Article 21 of the Town and Country Planning (General Development Procedure) Order 1995
Application for approval of details reserved by conditions 3 (surface water drainage), 4 (materials and finishes) and 9 (cycle storage) following a grant of planning permission M/71/13/.
White Horses 9 Main Drive, Middleton on Sea,

Arun District Council have decided to **REFUSE details reserved by condition for the following reasons:**

GROUND FLOOR PLANS to PLOTS 1 and 2

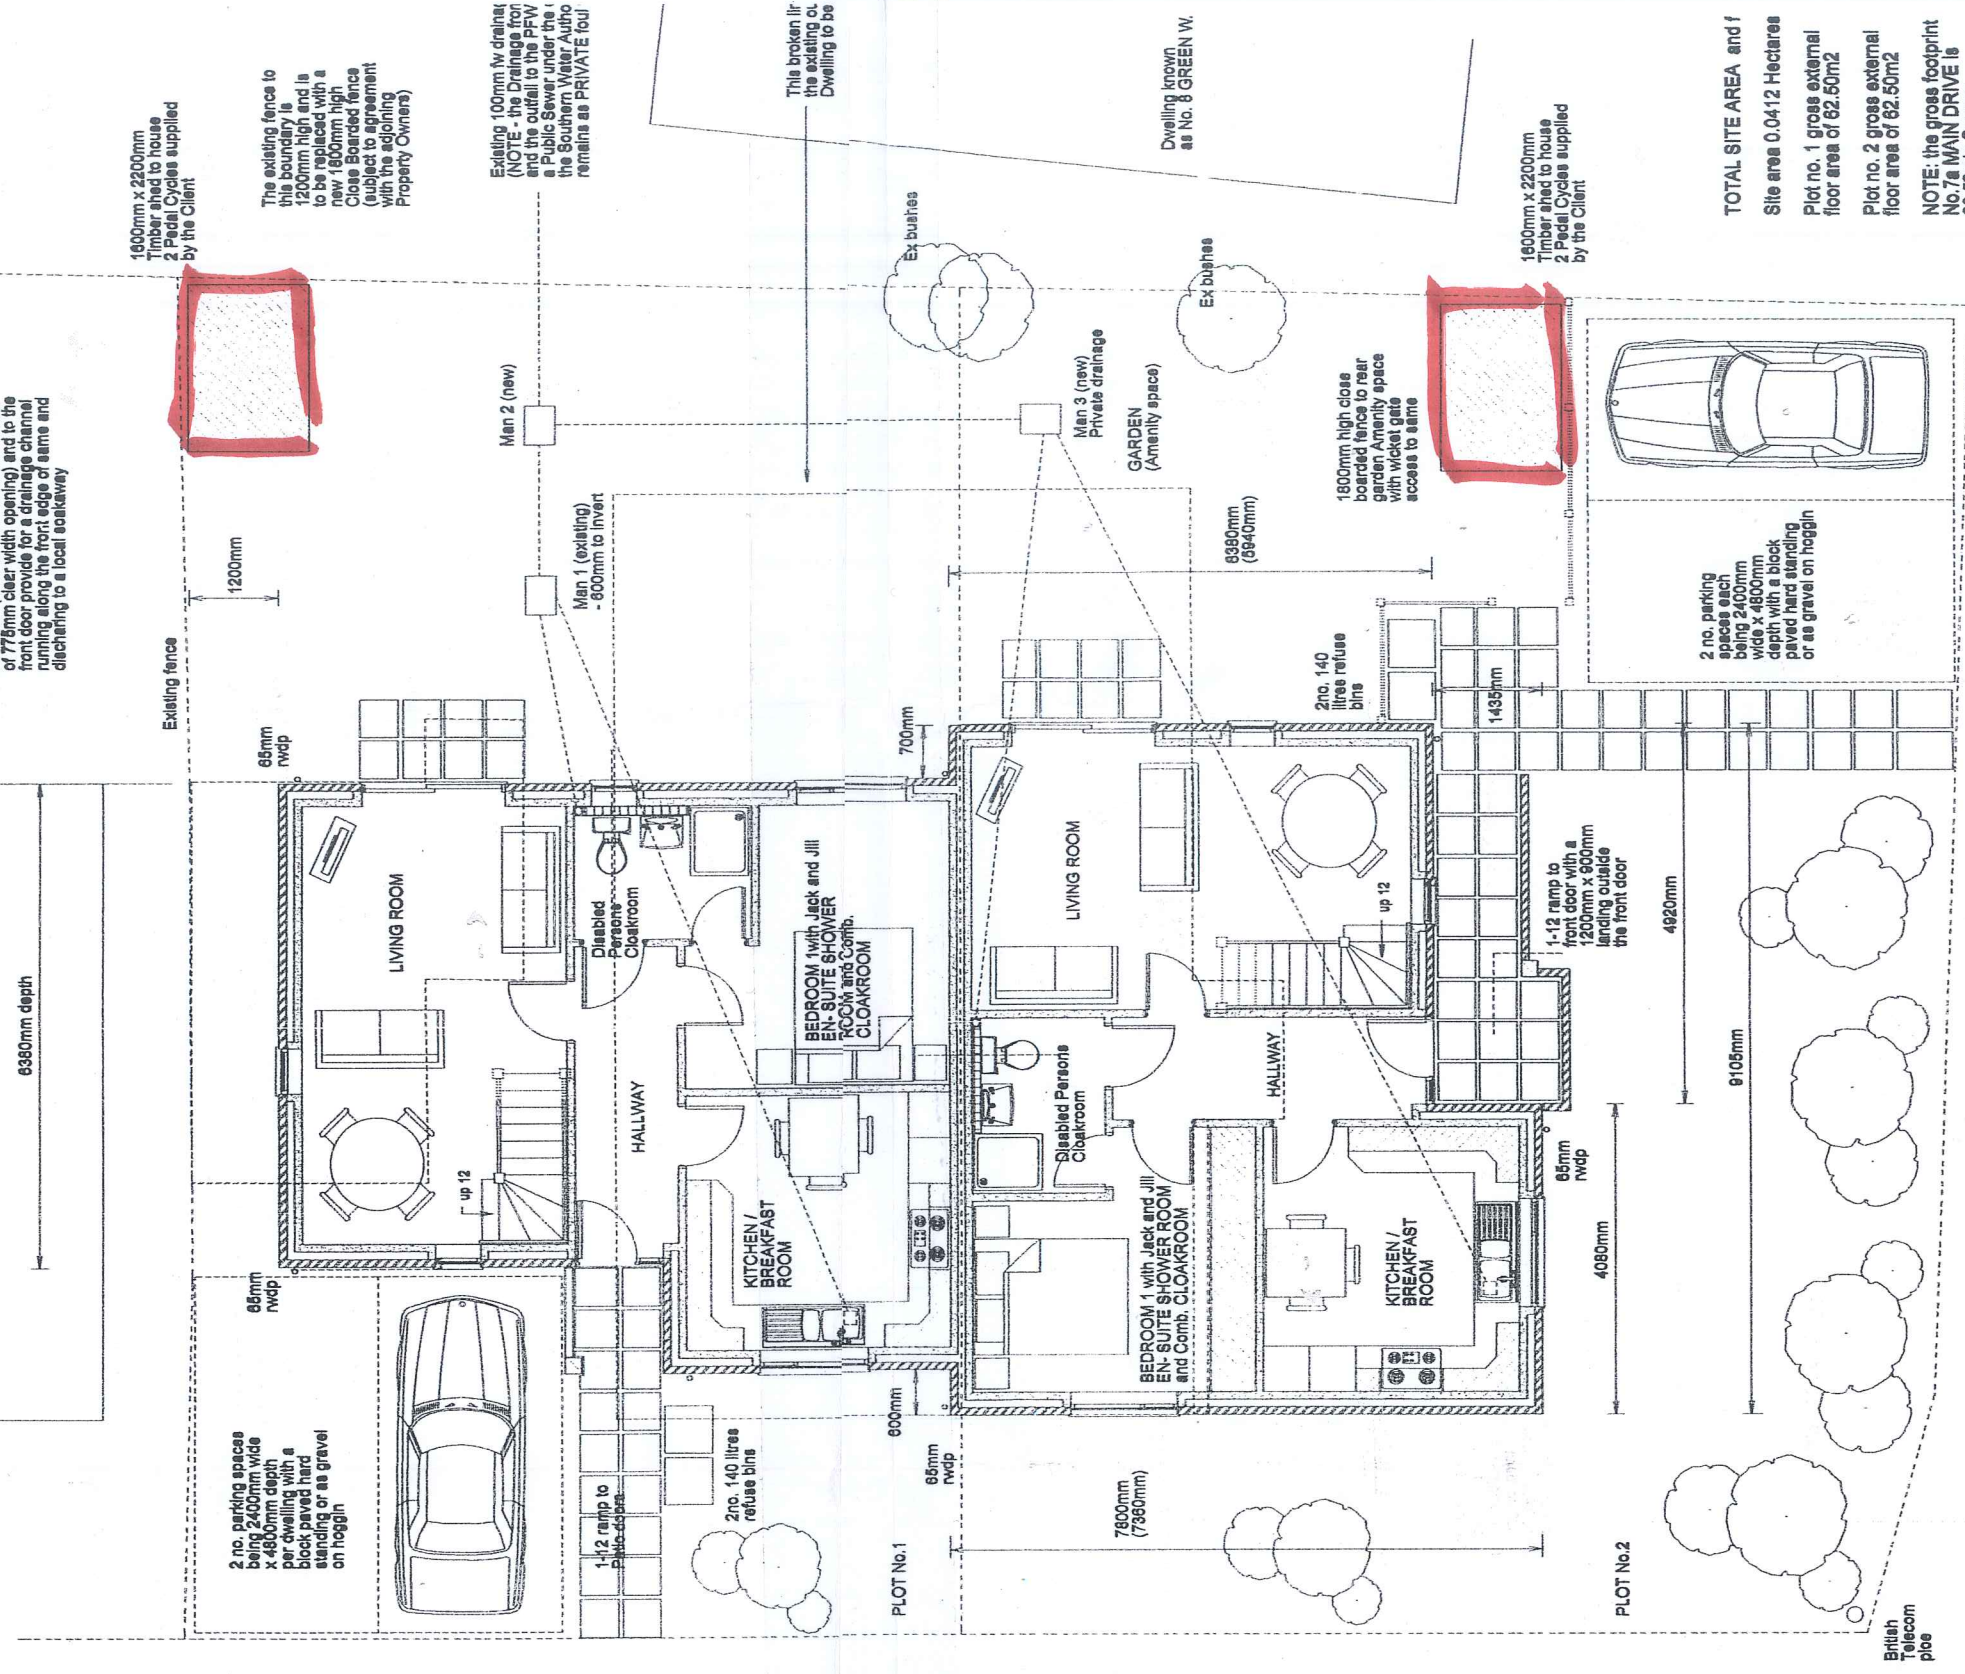
Whilst evidence that soakaways can be constructed with a base no lower than 1.18 mbgl. has been provided, percolation test results are still required, so that the soakaways can be designed to a suitable storage volume, allowing for the 1 in 100 year storm +30% to be contained.
